Addendum No. 1

RE: Contract # C204594

Beaufort County (B-5302)

BRIDGE #3 OVER NORFOLK SOUTHERN RAILROAD ON US-17 BUS
AND BRIDGE #25 ON US-17 BUS OVER PAMLICO RIVER

PROJECT REFERENCE NO.	SHEET NO.
B-5302	U0-2
THIS SHEET CORRESPONDS TO RDY-4

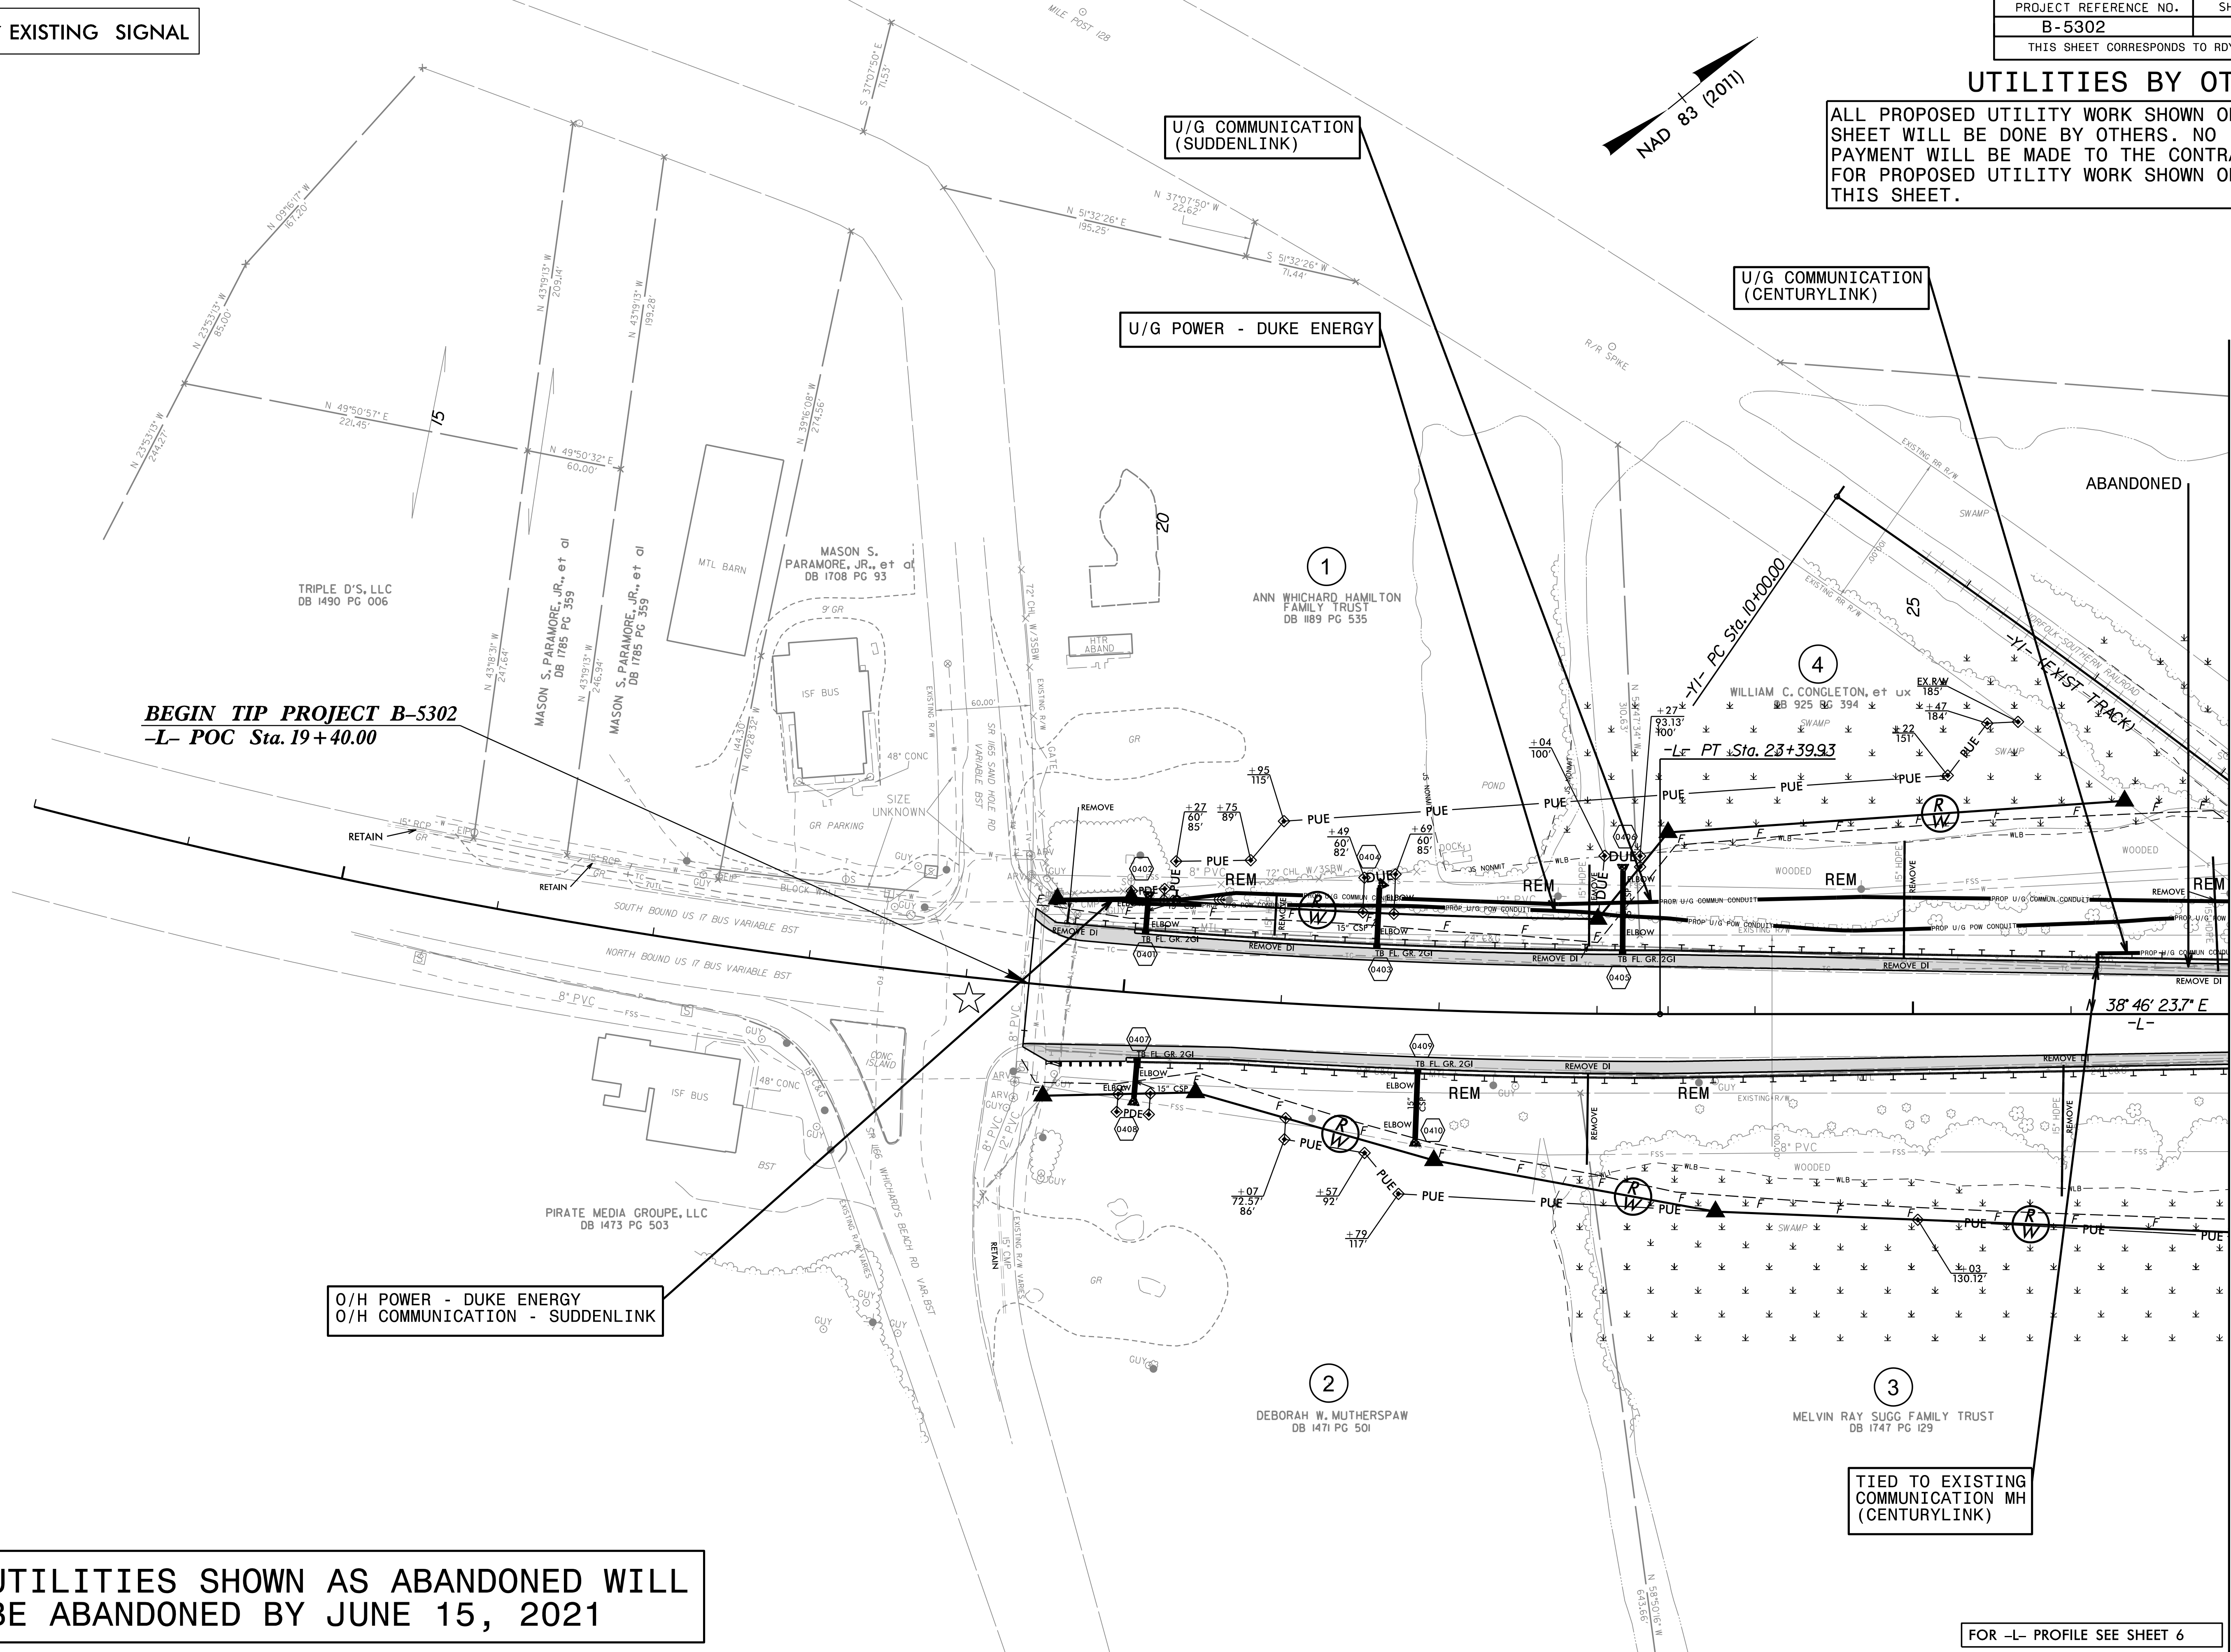
Sheet No.	Revision
UO-2	Note revised to reflect correct Utility abandonment date
UO-3	Note revised to reflect correct Utility abandonment date
